An  
Bord  
Pleanála

## Inspector's Addendum Report ABP-306021-19

<b>Strategic Housing Development</b>	544 no. dwellings, 2 no crèches, open space and associated works.
<b>Location</b>	Lands at Belmont, Academy Street, Navan, Co Meath
<b>Planning Authority</b>	Meath County Council
<b>Applicant</b>	Coindale Ltd.
<b>Prescribed Bodies</b>	Irish Water Transport Infrastructure Ireland Department of Culture, Heritage and the Gaeltacht.
<b>Observer(s)</b>	Alice Clynch,

Drawing file: Engineering Drawings / D061-045 Swept Path Analysis Fire Tender.pdf

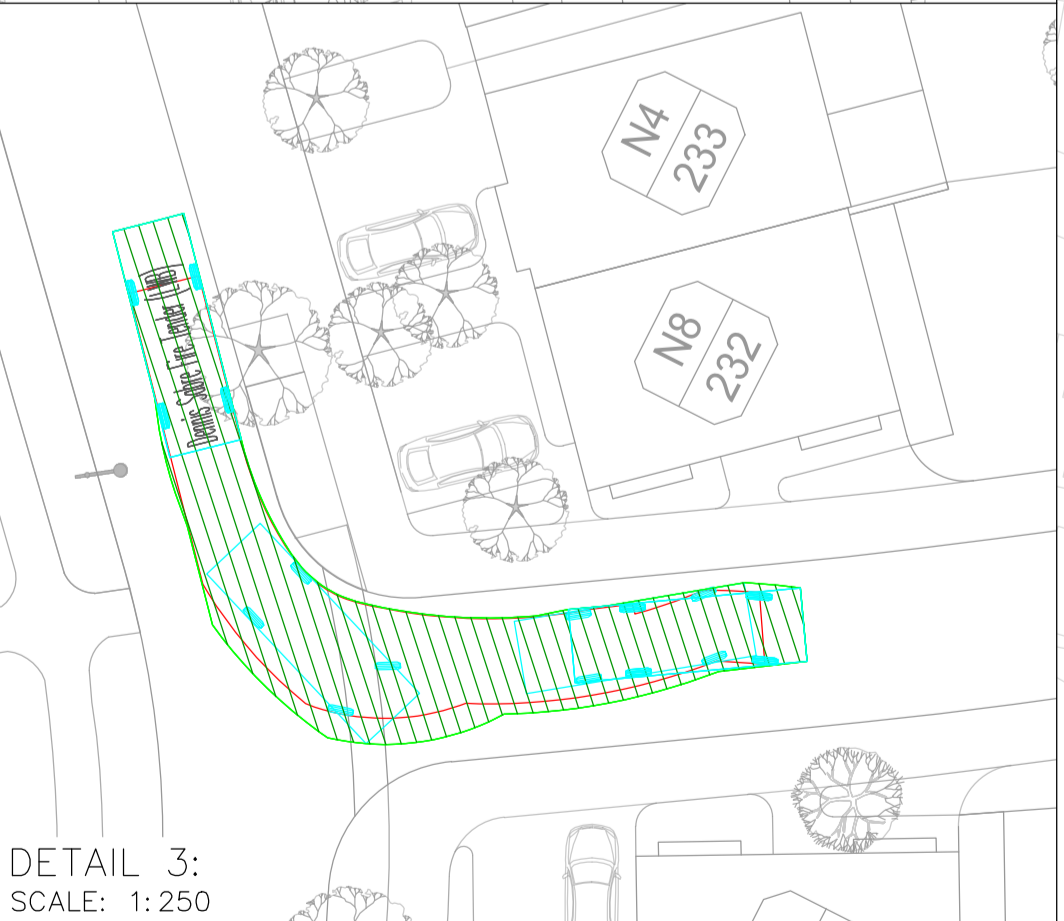
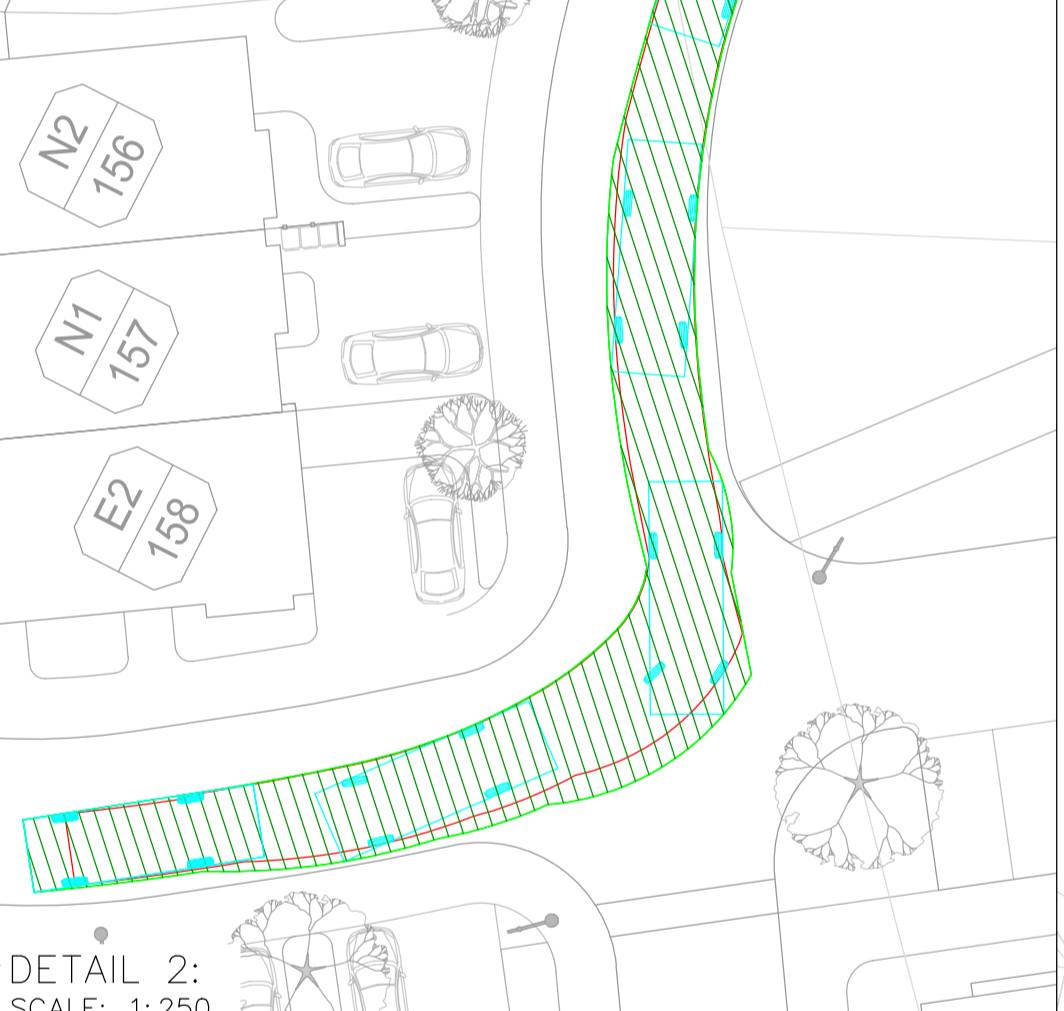
- 3.5. The amended site layout plan illustrates part of the area adjoining Access 4 as communal open space for use by the duplex units. The management of both the communal area and the new accesses, Route A-B & X-Y, will be a matter for a management company. An Outline Emergency Access Plan accompanied the information submitted, which I have accessed and consider acceptable. The submission of a final agreed plan can be reasonably conditioned as part of any grant of permission. The orientation of the duplex units in Block 1 are such that they will provide passive surveillance for both the communal open space and Access 4. Landscaping details for the amended scheme include the removal of one category B tree and additional planting is integrated into the amended landscaping plan, which I consider reasonable. Route X-Y will be finished with grasscrete providing integration into the landscaping and facilitating access for emergency tenders.

- 3.6. The PA confirmed no objection to the design or use of Access 4 and are satisfied with the overall proposal to accommodate access for emergency tenders to the site in the event of an extreme flood event. The PA noted that should the Board be of a mind to grant permission, details relating to the design, phasing and delivery of the access and associated works should be conditioned prior to the occupation of any unit. I consider the applicant has provided sufficient detail in the amended scheme to assess the impact of both Access 4 and the internal route to the apartments. I do not consider the use of a farm gate along the R147/ Dublin Road appropriate for a

External Boundary Treatments
1:1500 @ A1

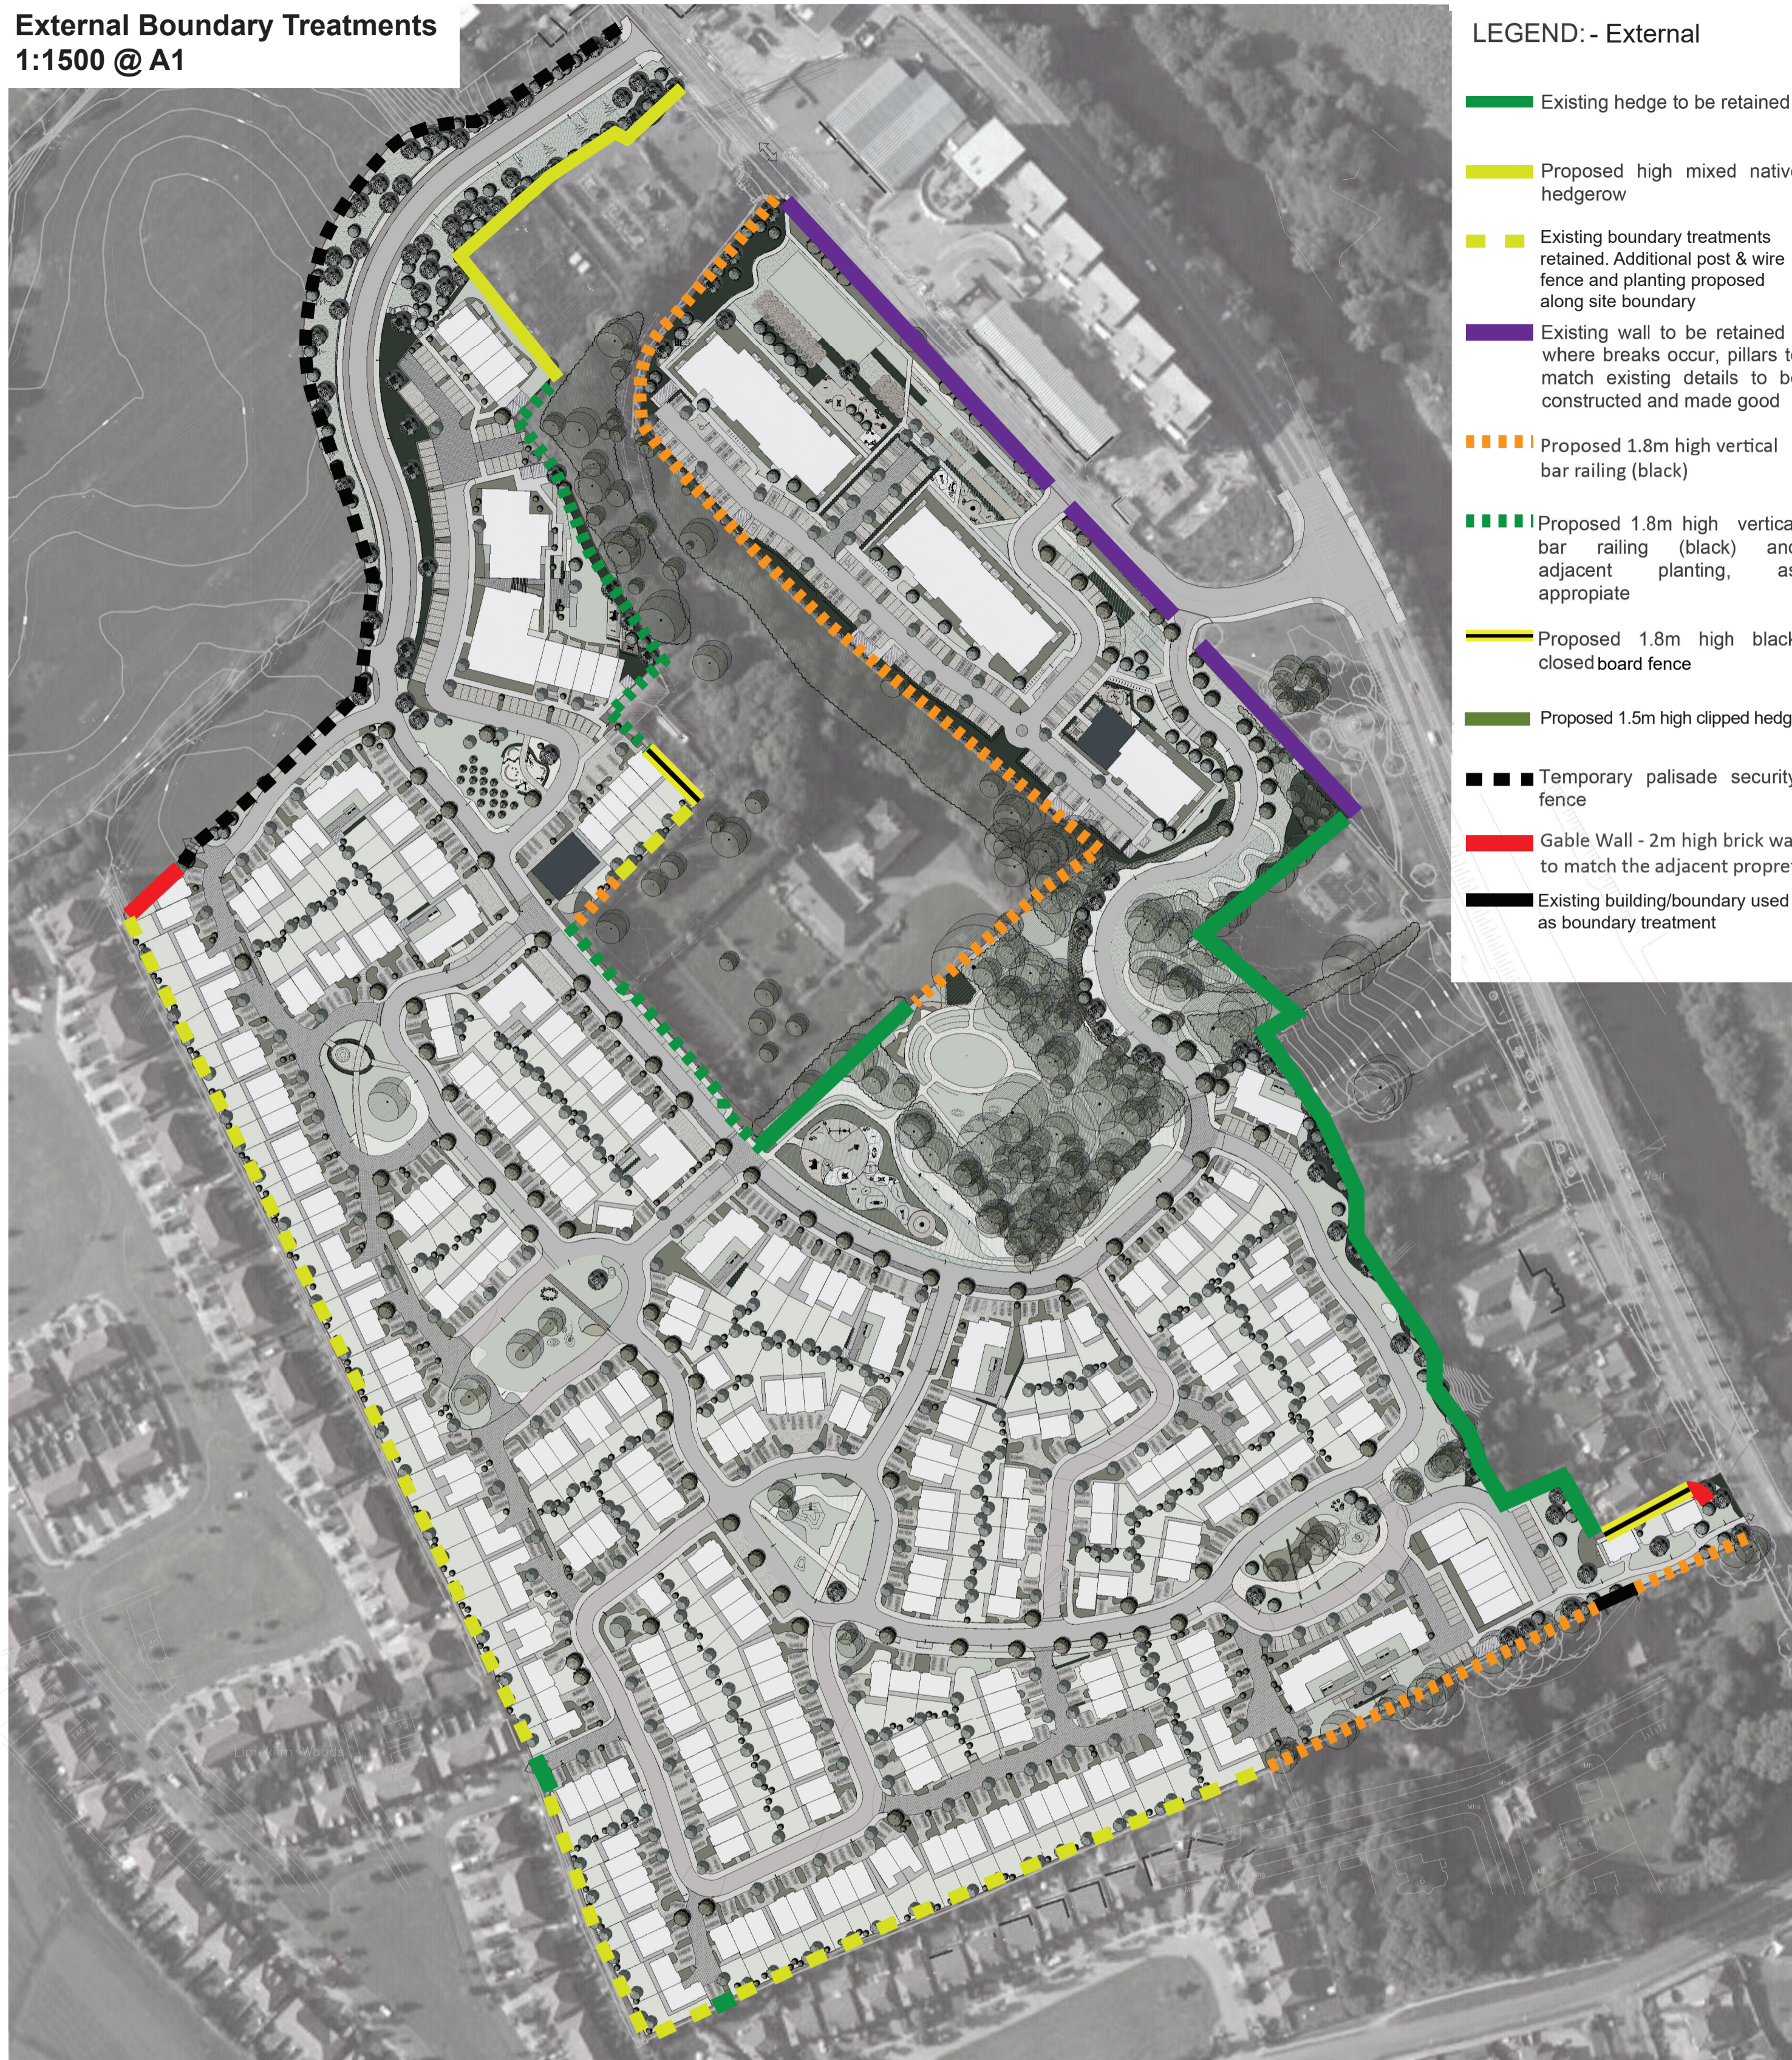
The Inspector further clarified with MCC, if there were any specific comments on the boundary treatment along the emergency access. MCC proposed that specific details for the boundary treatment is agreed prior to any commencement. Further detail relating to the set back of the new entrance could also be conditioned.

residential scheme and an alternative treatment should be included, which I consider can be reasonably conditioned.
